DRB Application No.: 05DRB-00056(P&F)  
Project Name Mesa Verde Addition  
Agent: Doug Smith Surveying

**CITY OF ALBUQUERQUE  
PLANNING DEPARTMENT  
January 19,2005  
DRB Comments**

**PROJECT # 1003884      APPLICATION # 05-00056**

**RE: Lots 29-32, Block 37, Mesa Verde Addition/minor plat**

**PLAT**  
 OF  
**LOTS 29-A AND 32-A**  
**BLOCK 37**  
**MESA VERDE ADDITION**  
 SECTION 19, TOWNSHIP 10 NORTH, RANGE 4 EAST, N.M.P.M.  
 CITY OF ALBUQUERQUE, BERNALILLO COUNTY, NEW MEXICO  
 DECEMBER, 2004

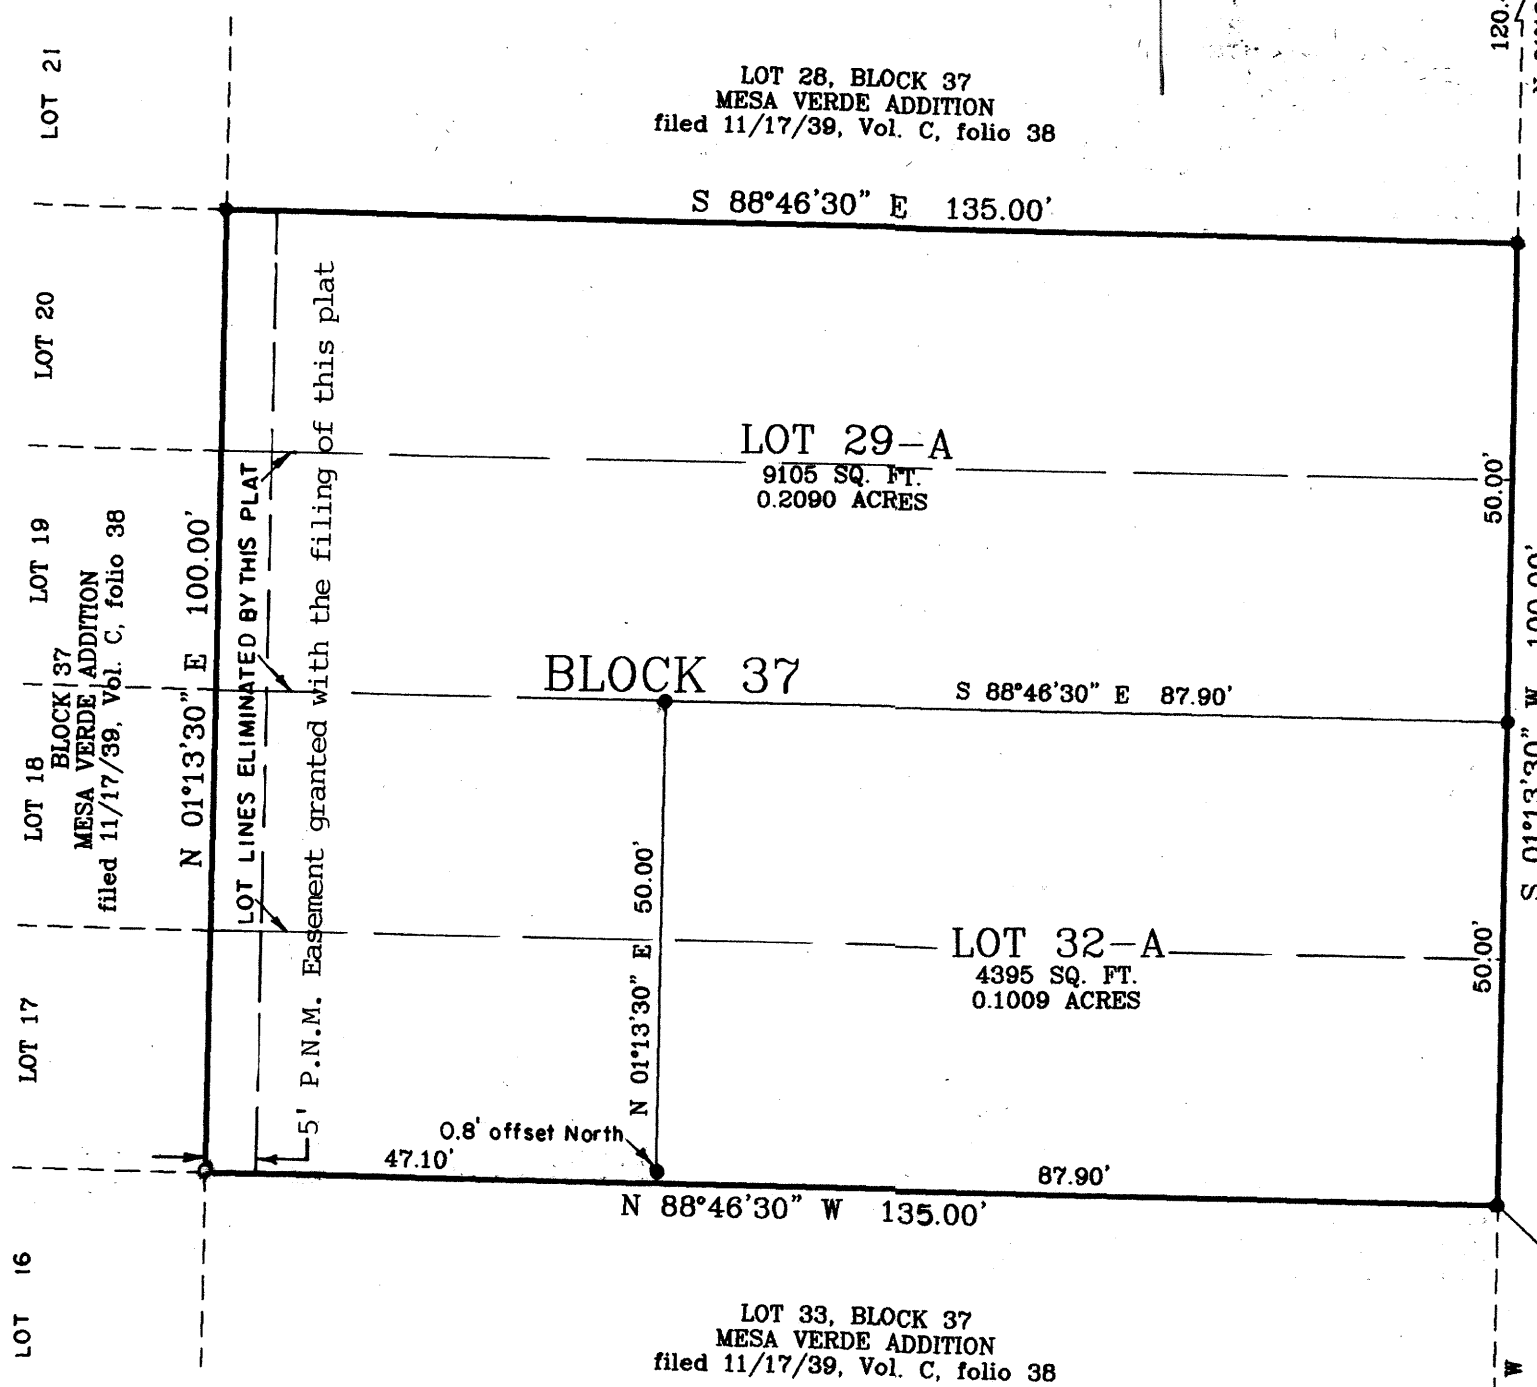
**What is the "Bldg" identified on sketch?**

**Non-conforming setbacks shown are existing on 2 residences.**
